Submission: Project Mars Data Centre, SSD-82052708

I **object** to the Project Mars Data Centre at 12 Mars Rd Lane Cove West for the following reasons:

DRAWING TITLE  
Tree Retention Plan

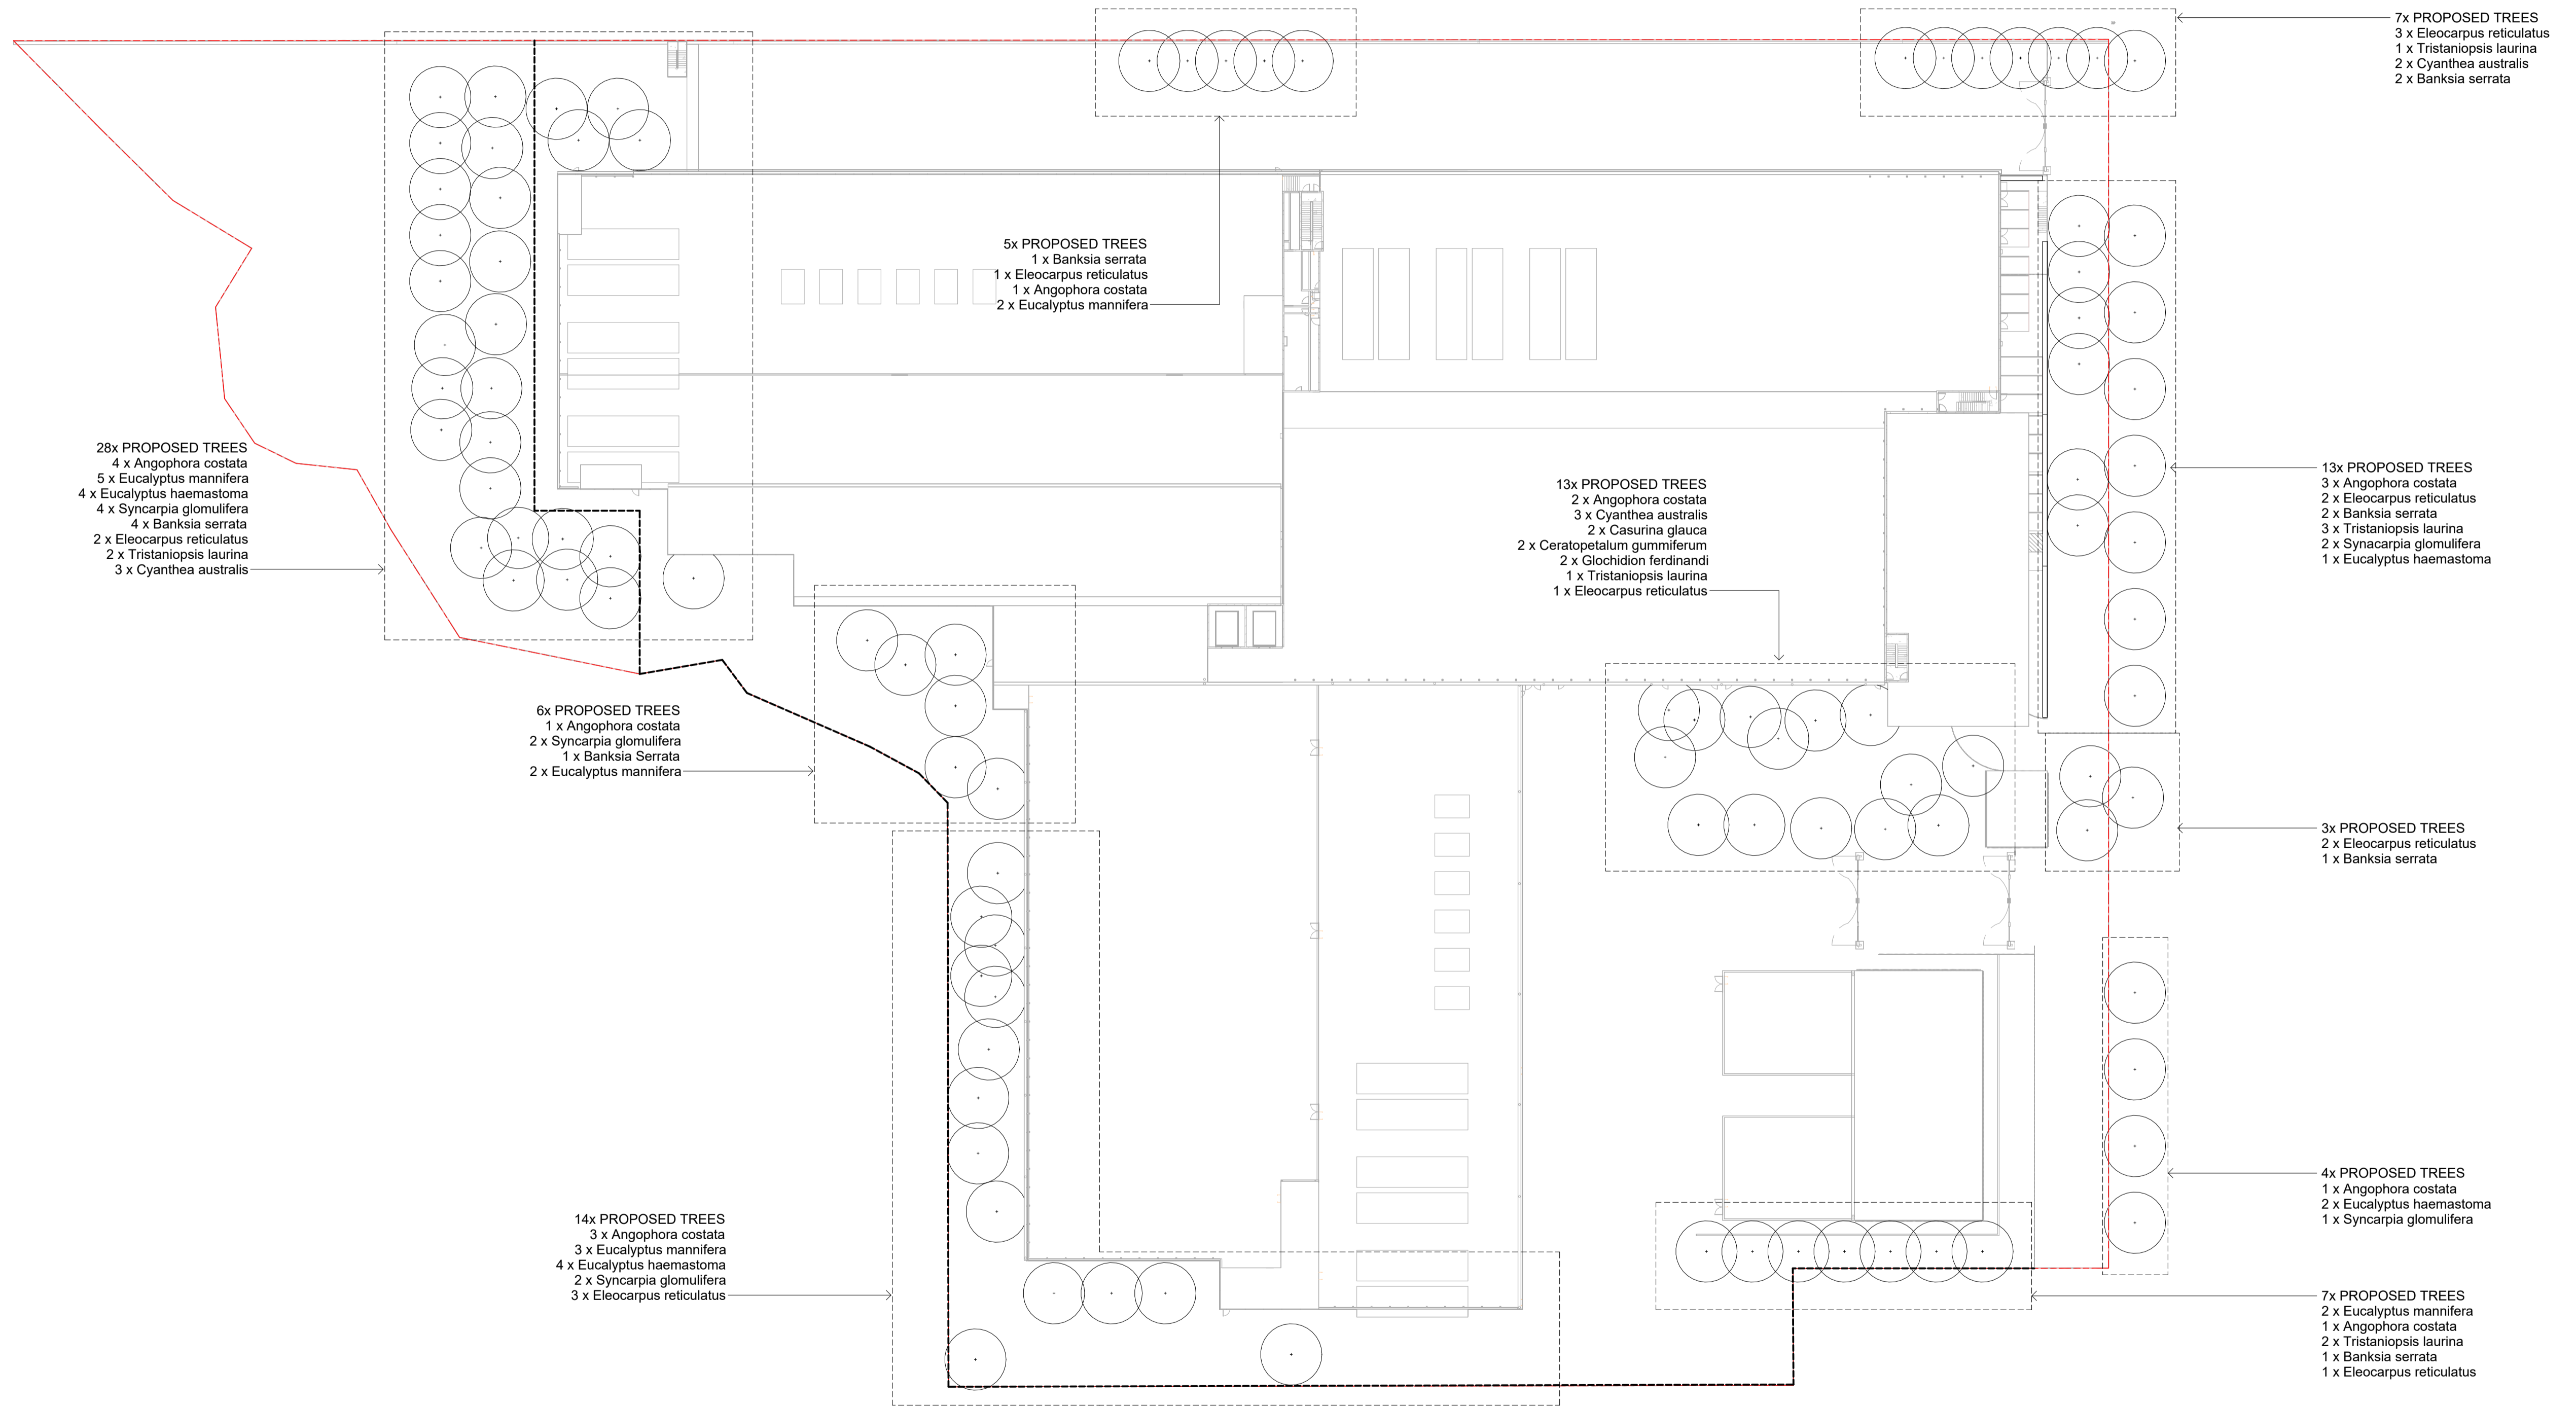
Having lived in Banksia Close for over 18 years we are aware of the wildlife that calls this area home. 90 trees will be removed in the construction phase of the project. Some of these have been identified as mature. This canopy provides a habitat for a range of birds and animals.

I can find no analysis in the Proposal of the animals and birds that use this area to live and nest. While the project proposes to replant over 100 trees they will take many years to reach maturity following construction. The mature canopy currently providing mitigation of both sound and light will change. This will impact on wildlife, in particular the nocturnal creatures that will be subjected to a change in noise and light.

DRAWING TITLE
SHADOW STUDY - AUTUMN

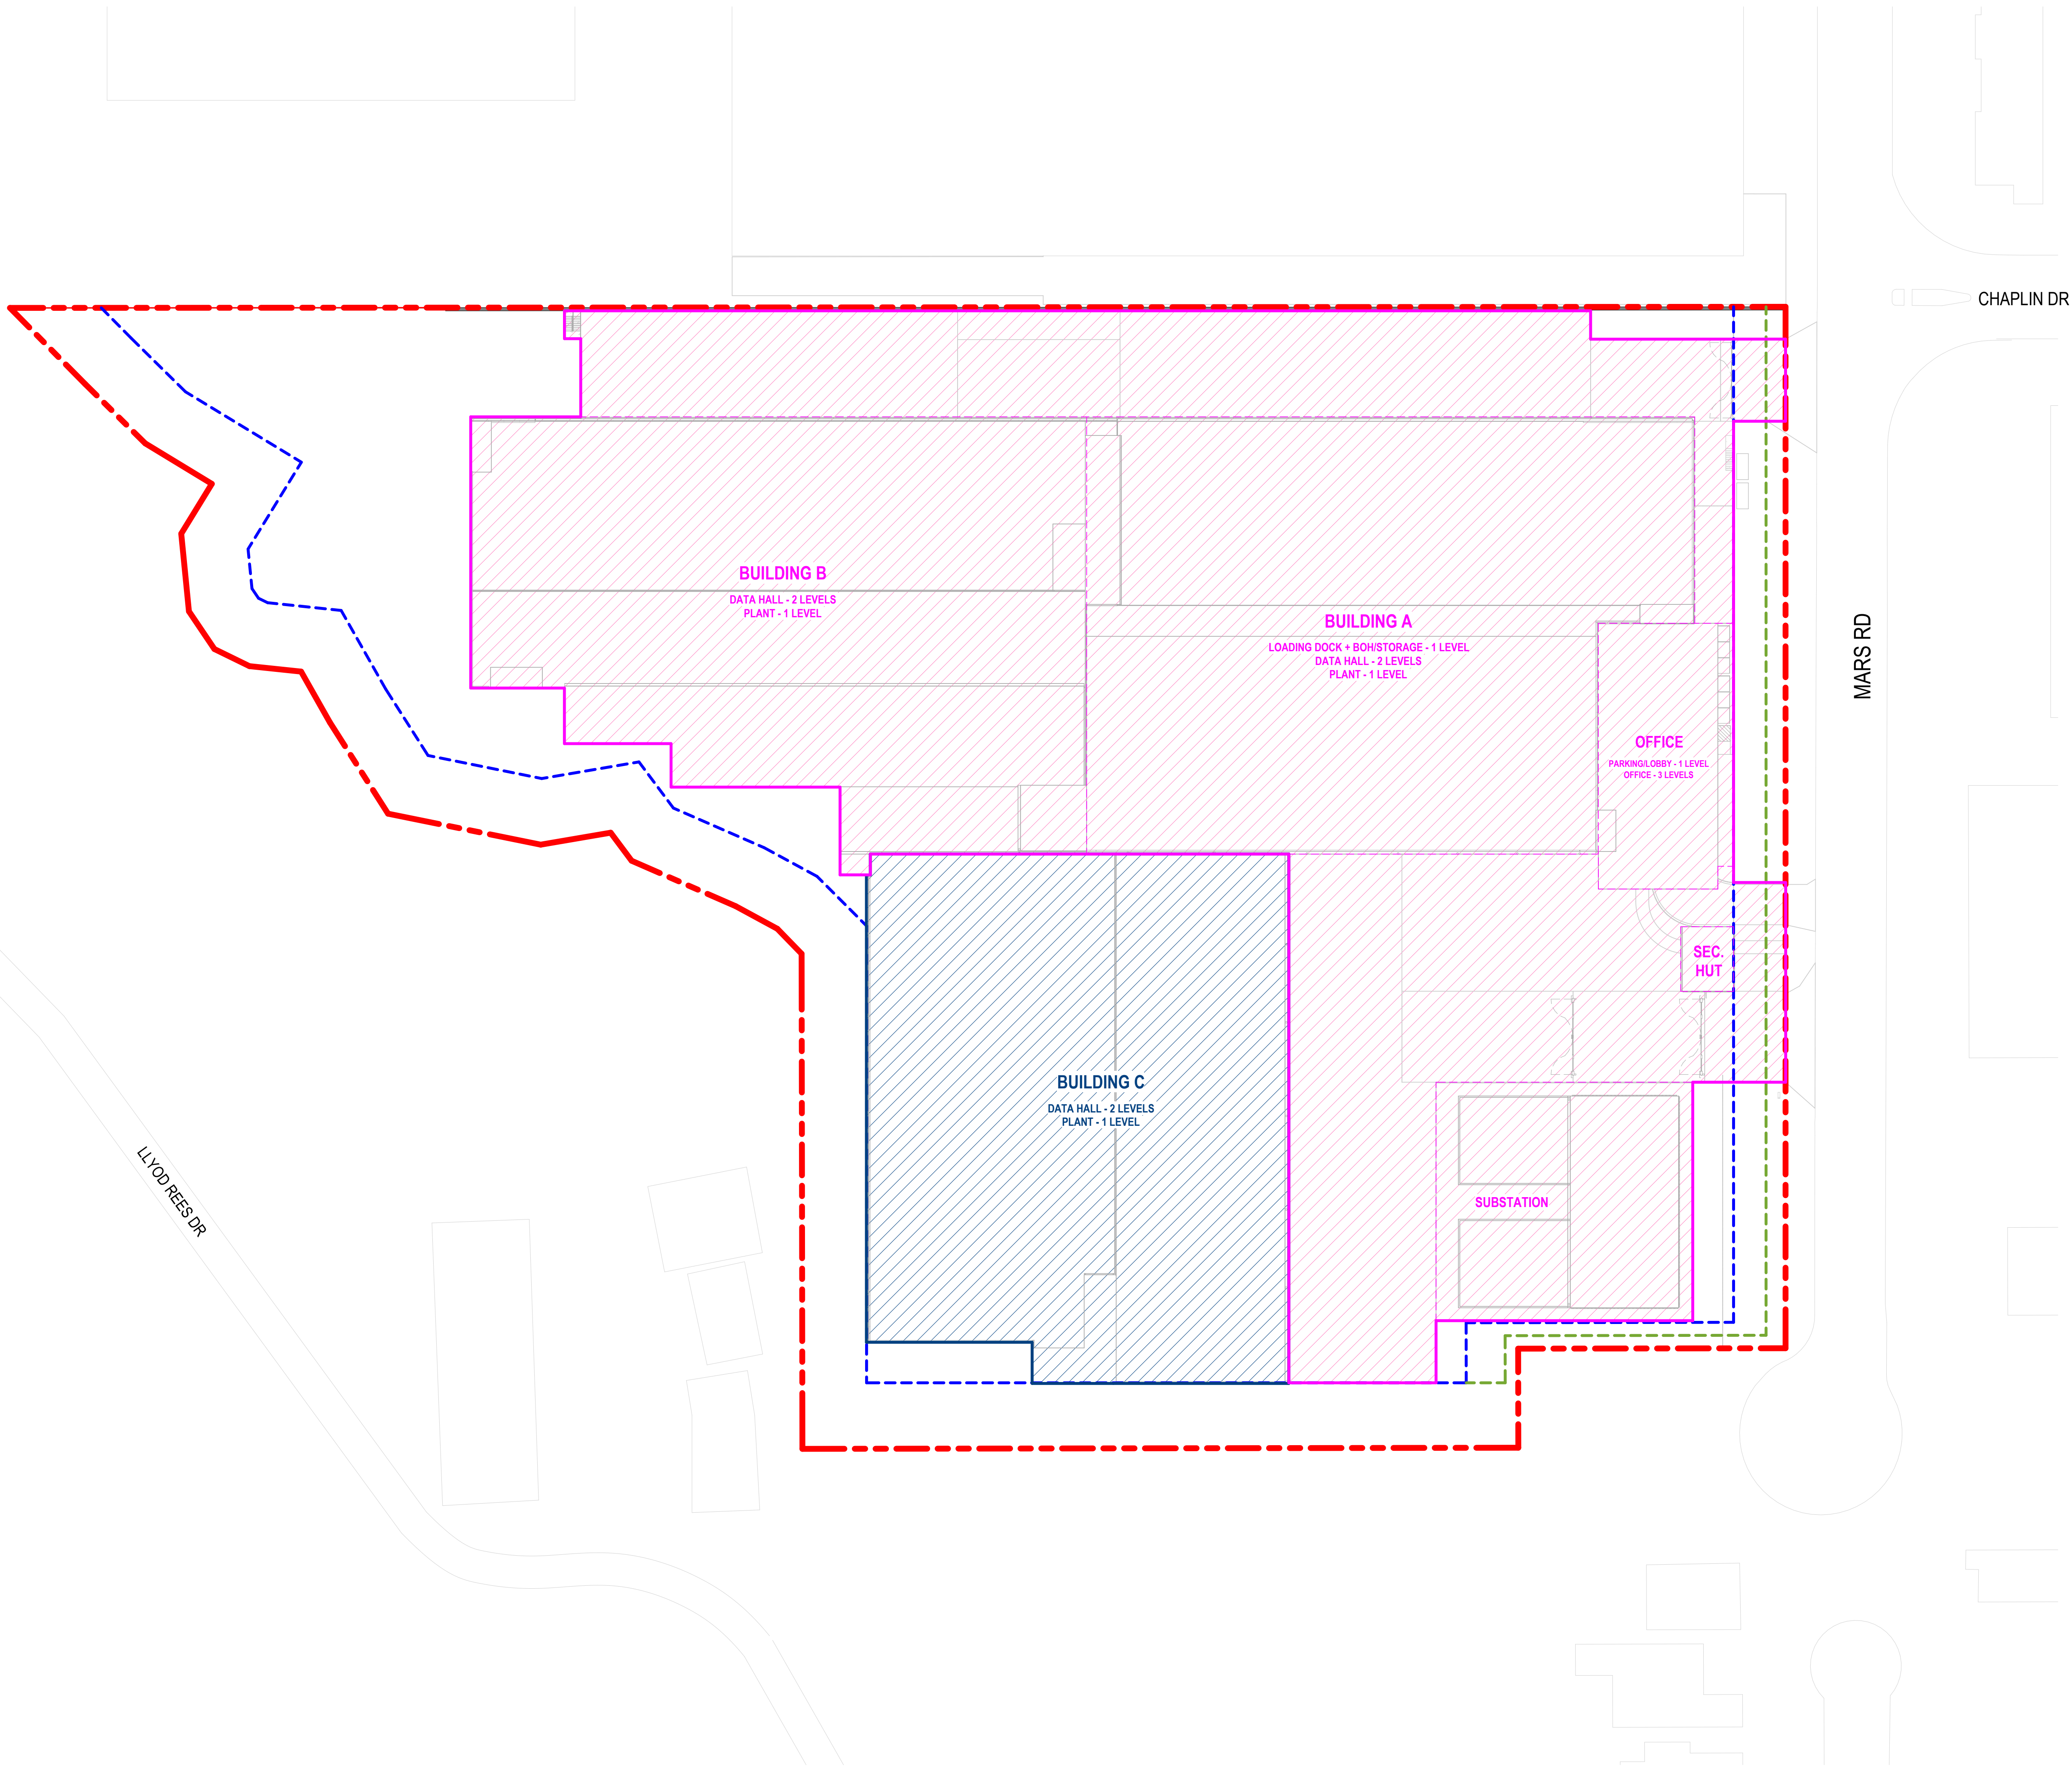
The walls of this substation will be 11.1 m which is considerably taller than a single story house and due to its proximity will definitely cast a shadow over 10 Banksia Close and the Lane Cove Community Nursery.
